**Our ref:** KT/2023/130482/01-L01  
**Your ref:** TR020005  
**Date:** 12 March 2024

**Gatwick Airport Northern Runway Development Consent Order Application -  
Written Representations on behalf of the Environment Agency – Deadline 1, 12  
March 2024**

- **Environmental Statement Chapter 5 - Project Description (Version 2)**

Figure 4.1: Schematic of Museum Field FCA

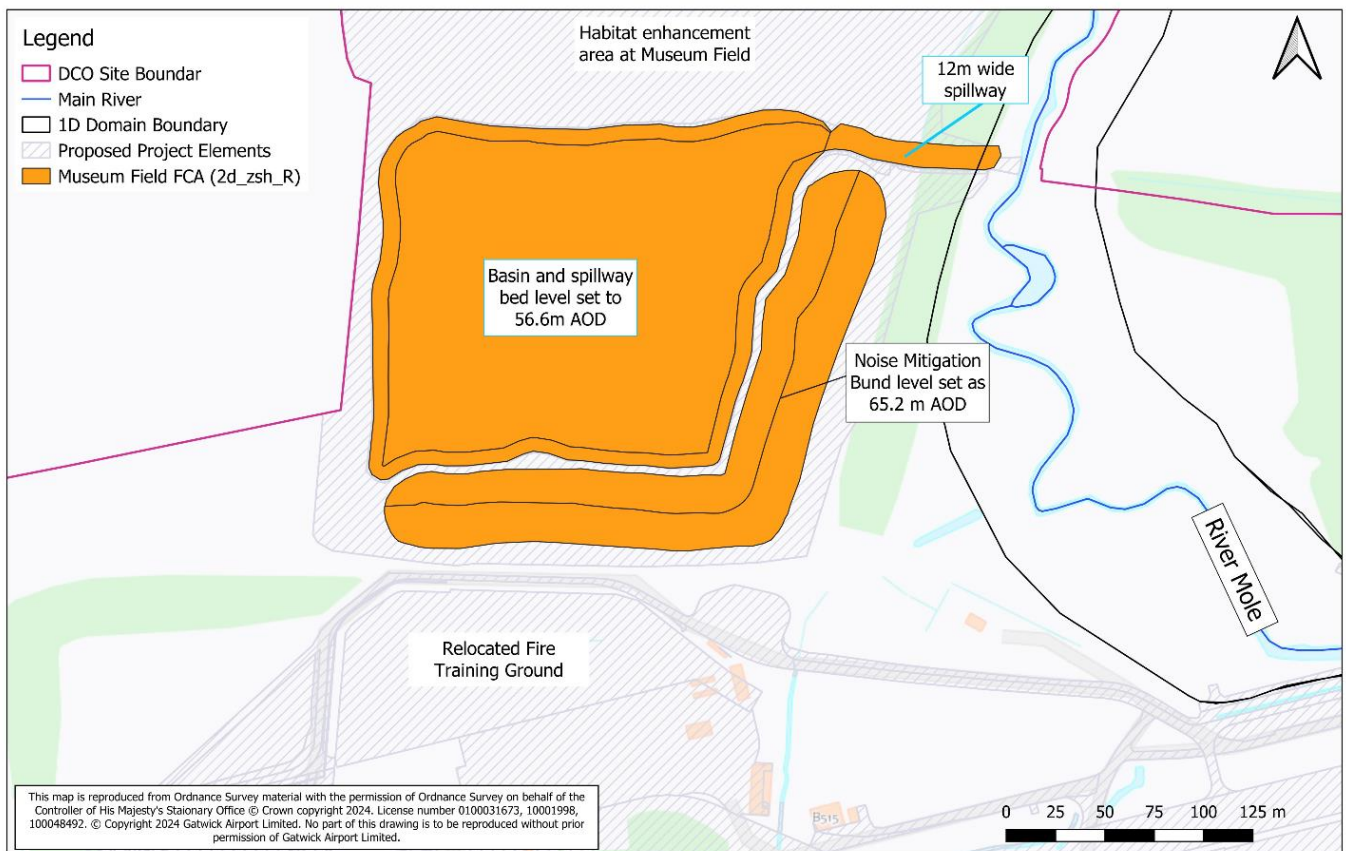
These Paragraphs seem reasonable. We have noted that the proposed capacities of both the FCAs are different in the updated Project Description to those in the November 2023 Flood Risk Assessment. We would question what capacities of FCA's were modelled as part of the with scheme modelling.

**Work No.38 Museum Field Flood Compensation Areas**. The description appears reasonable, but like Car Park X, an approximate capacity of 57,600m<sup>3</sup> is described in the updated Project Description. We request this approximate storage volume is written into the Draft DCO.

Figure 4.4: Schematic Drawing of the proposed Car Park X FCA

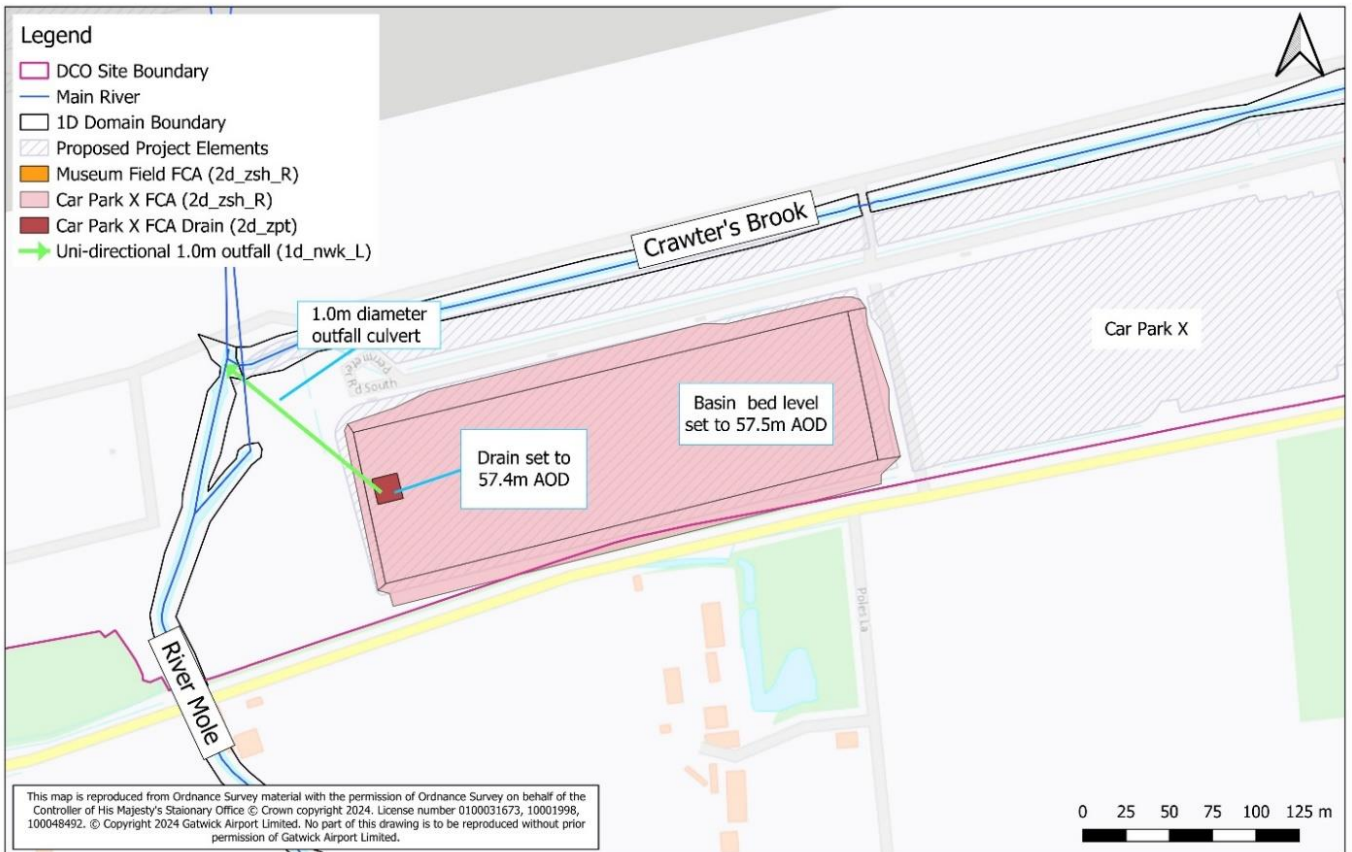
**Work No.31 Car Park X**, the description seems reasonable but there is no reference to the approximate storage capacity (given as 55,000m<sup>3</sup> in the updated project description). There is an approximate capacity associated with Car Park Y which is for surface water storage. We request this approximate storage volume for Car Park X is written into the Draft DCO.
